From: Masud Hasan <HasanM@liverpool.nsw.gov.au>
Sent: Wednesday, 26 July 2017 4:50 PM
To: Chloe Dunlop
Subject: Modification application for the Warehouse and Distribution Centre (SSD 7155 MOD 2) located at 5-35 Yarrunga Street, Prestons

Thanks for the opportunity to comment on the proposed modification application for the Warehouse and Distribution Centre (SSD 7155 MOD 2) located at 5-35 Yarrunga Street, Prestons. Please find below our submission in relation to the proposed modification and the associated developments on the site.

EAST ELEVATION  
WAREHOUSE 4 - SPORTS CENTRE  
1: 300 scale

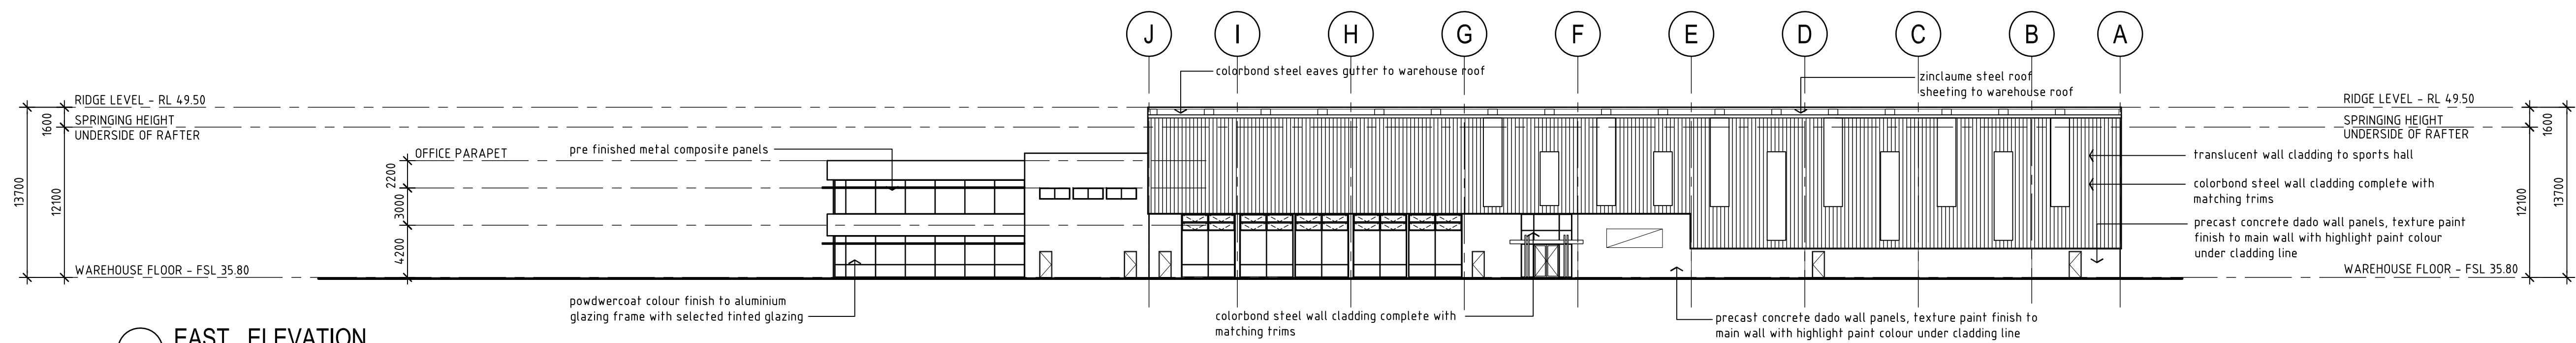
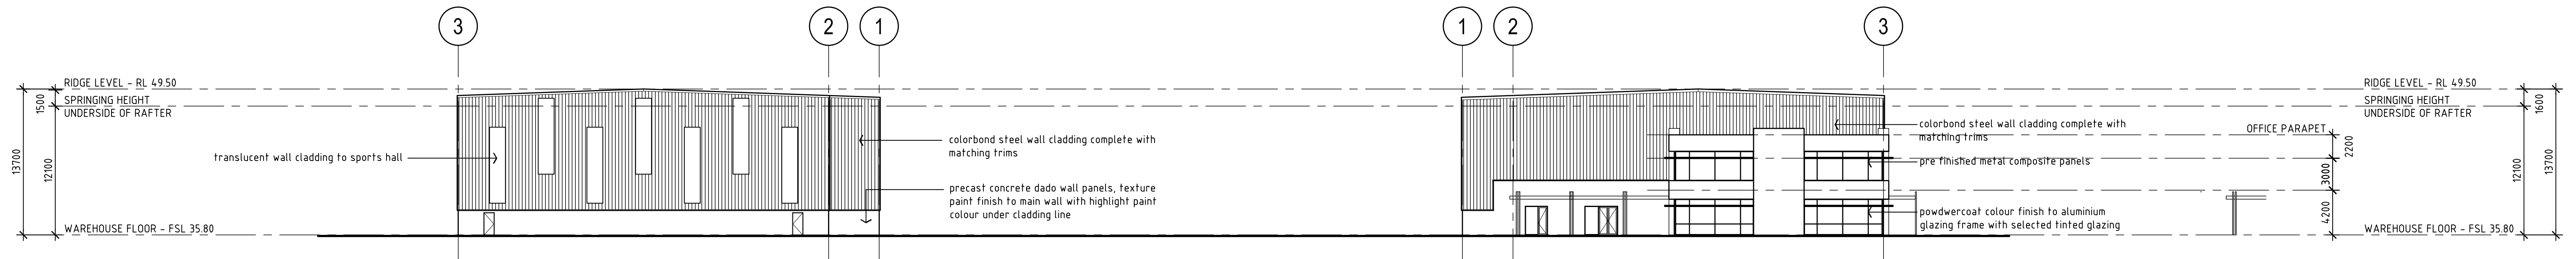
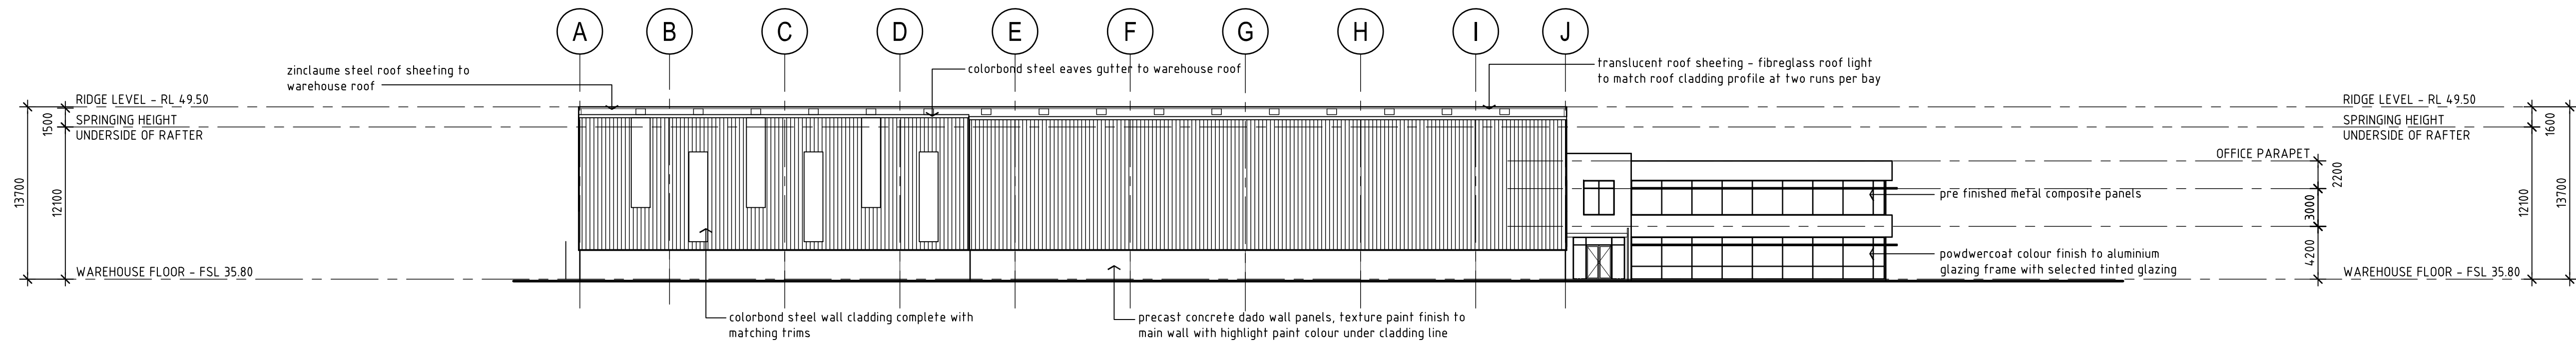
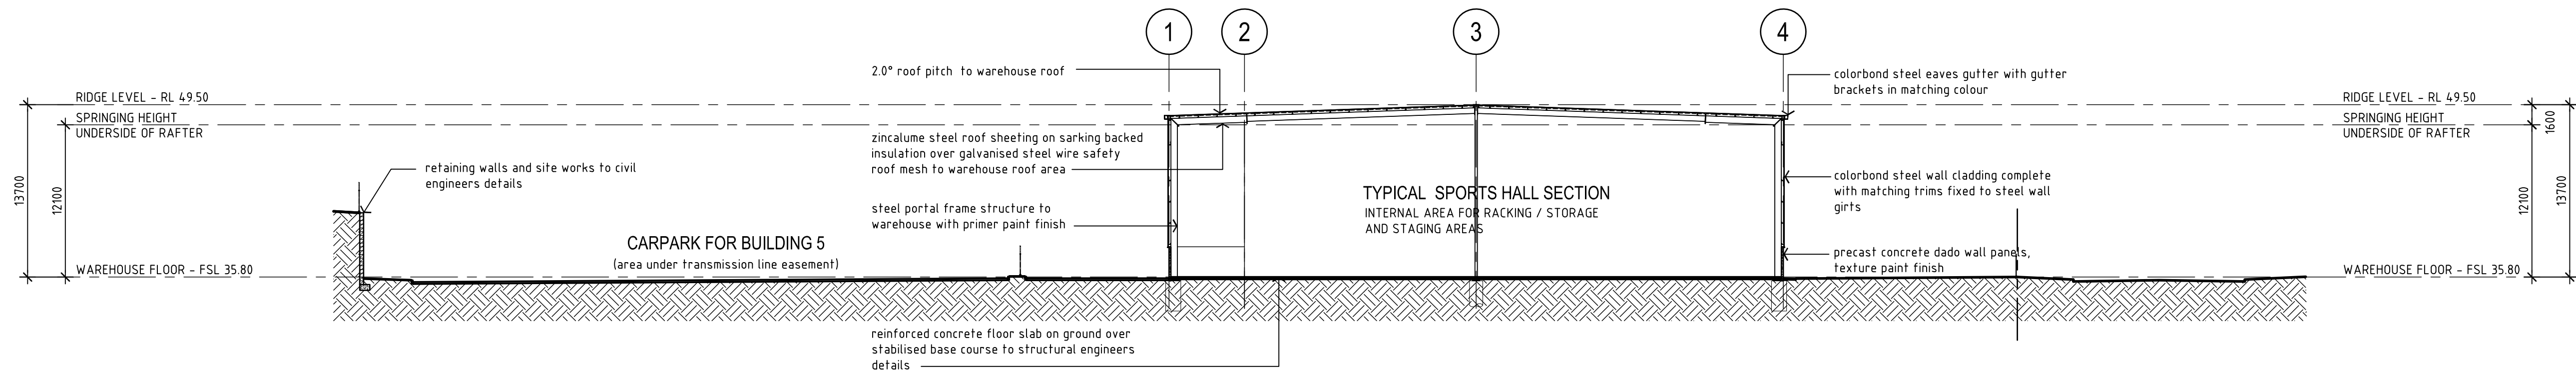
- It is recommended to reduce the visual bulk of industrial development along the Bernera Road frontage through the use of articulation and utilisation of suitable colour scheme.

SITE PLAN  
1: 1200 scale

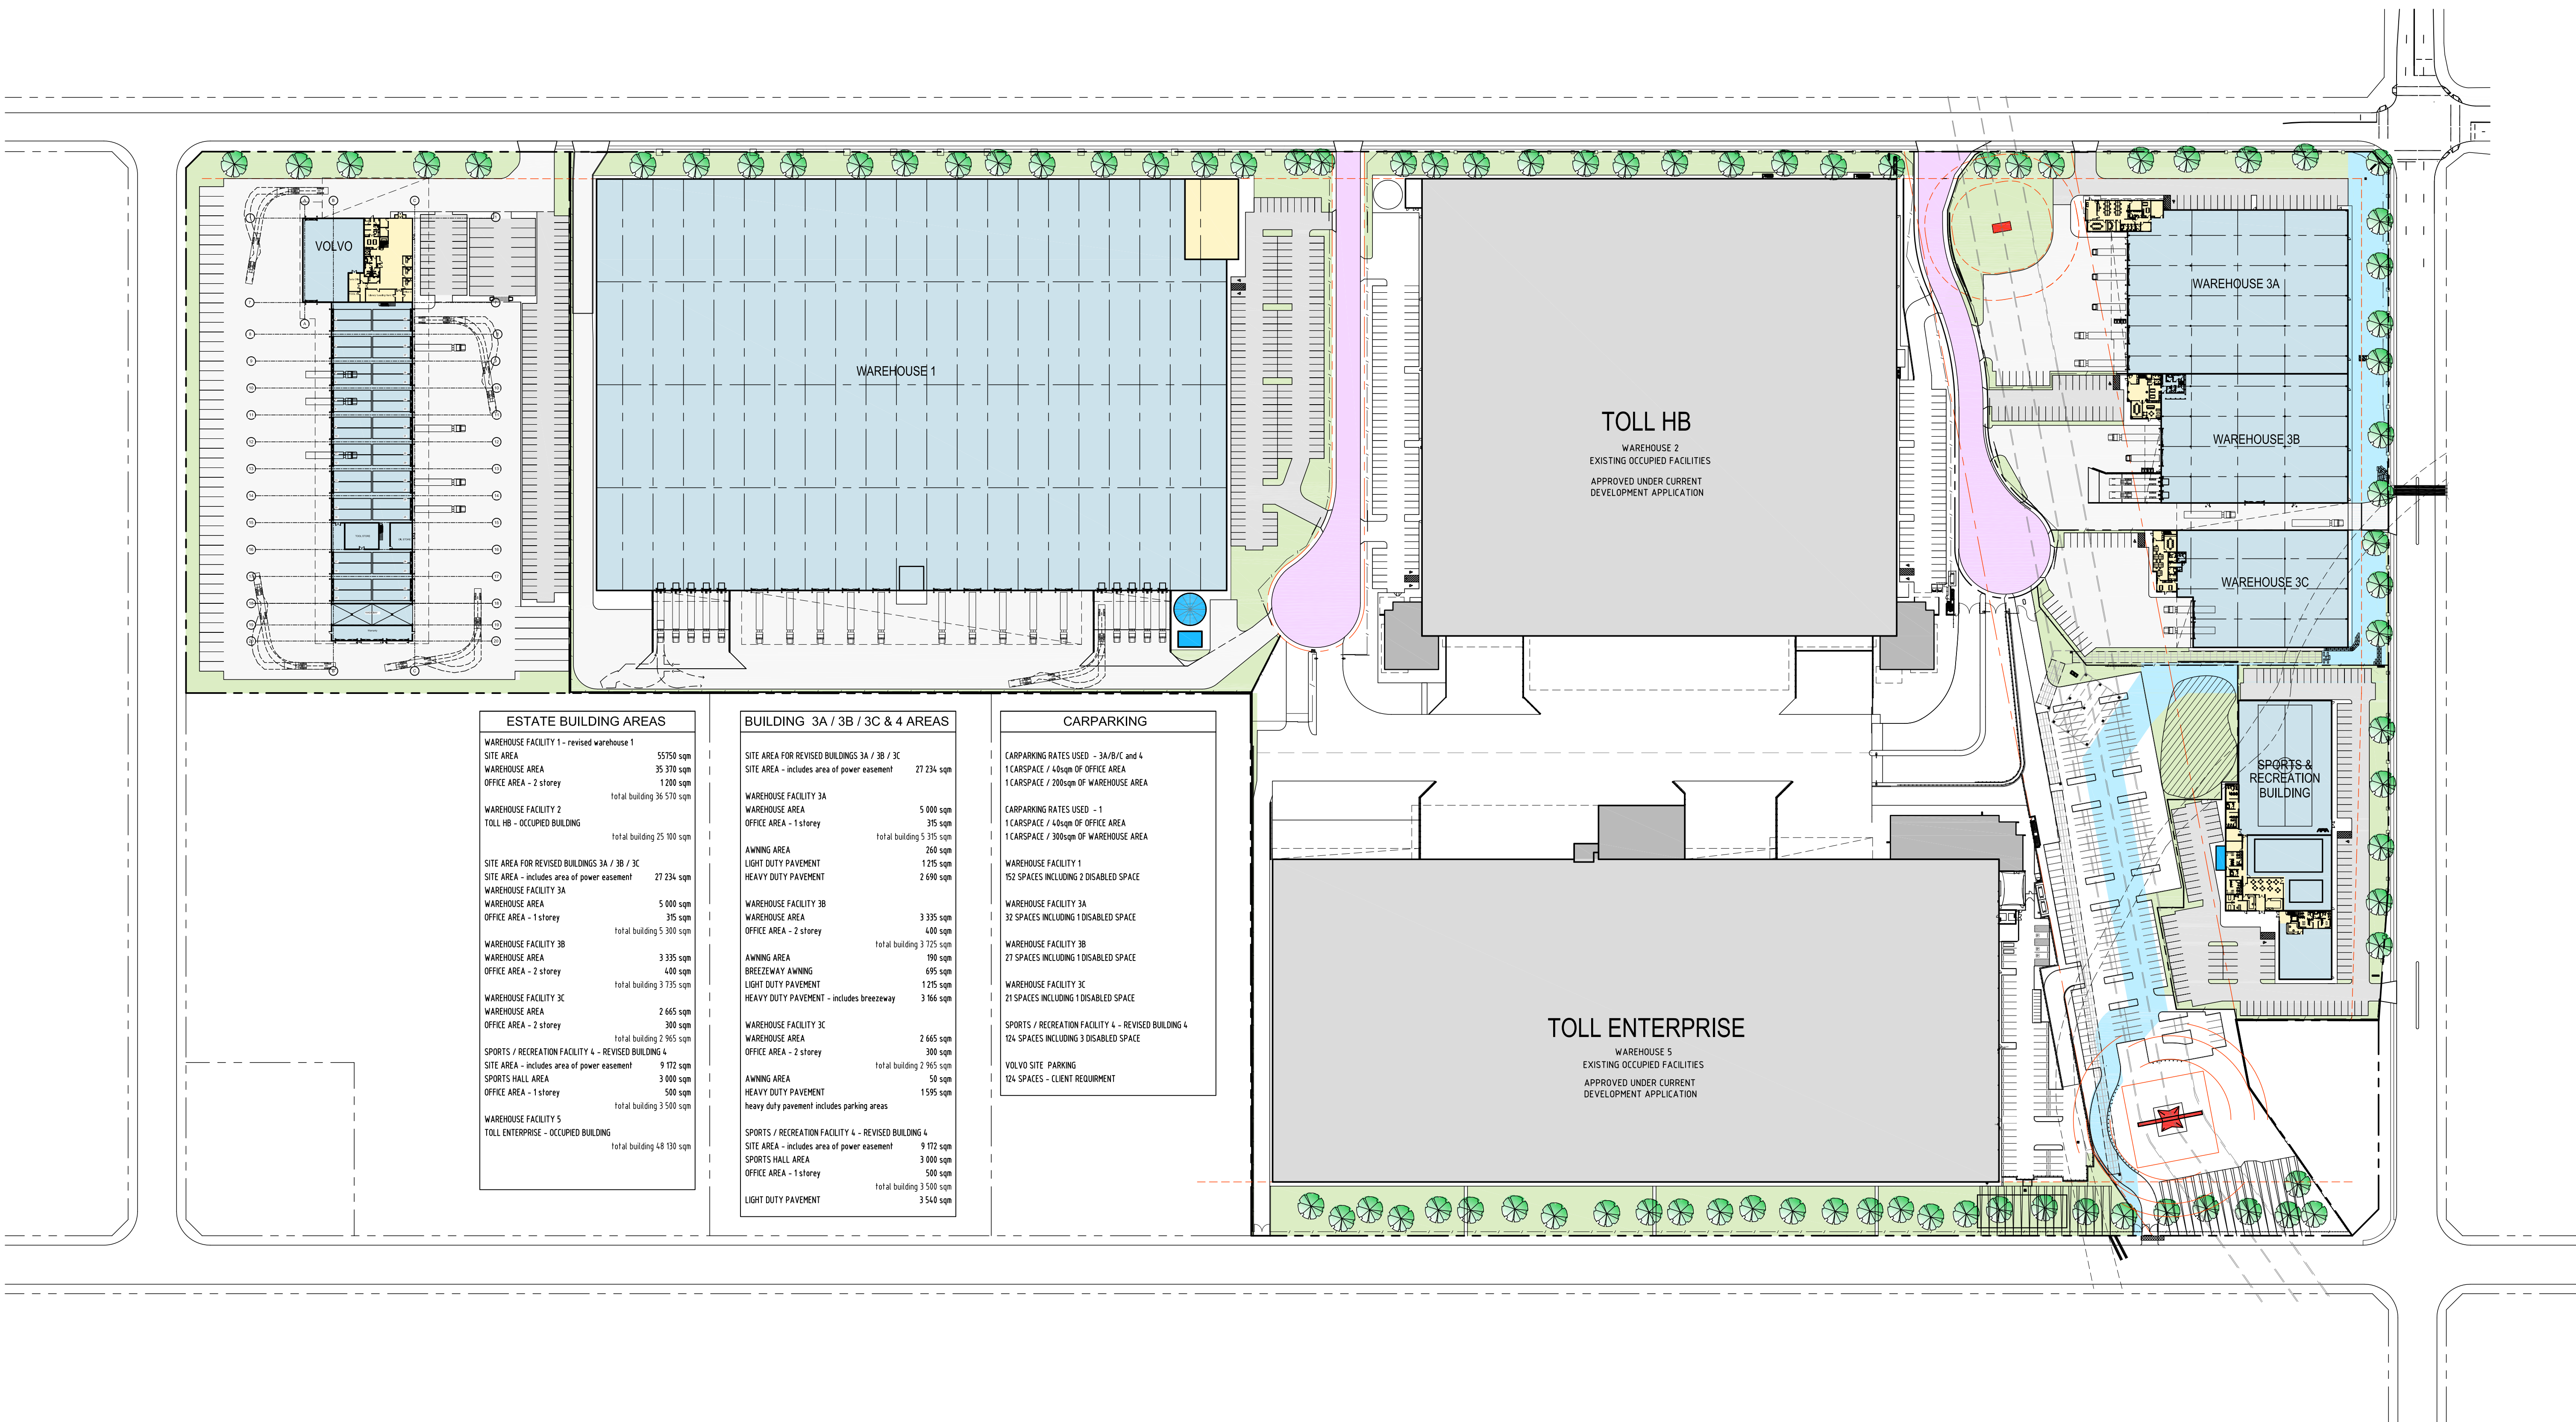
- 'Car parking' and 'Indoor Recreation Facilities' are prohibited use in the IN3 - Heavy Industrial zone under Liverpool LEP2008. Staff car parking for Warehouse 4 needs to be relocated within the IN1 (General Industrial) zone where it is permissible. This will assist to preserve the demarcation of the two different industrial zones.

- It is identified that fewer parking spaces are provided in the proposal compared to the car spaces needed as per Council's standard.
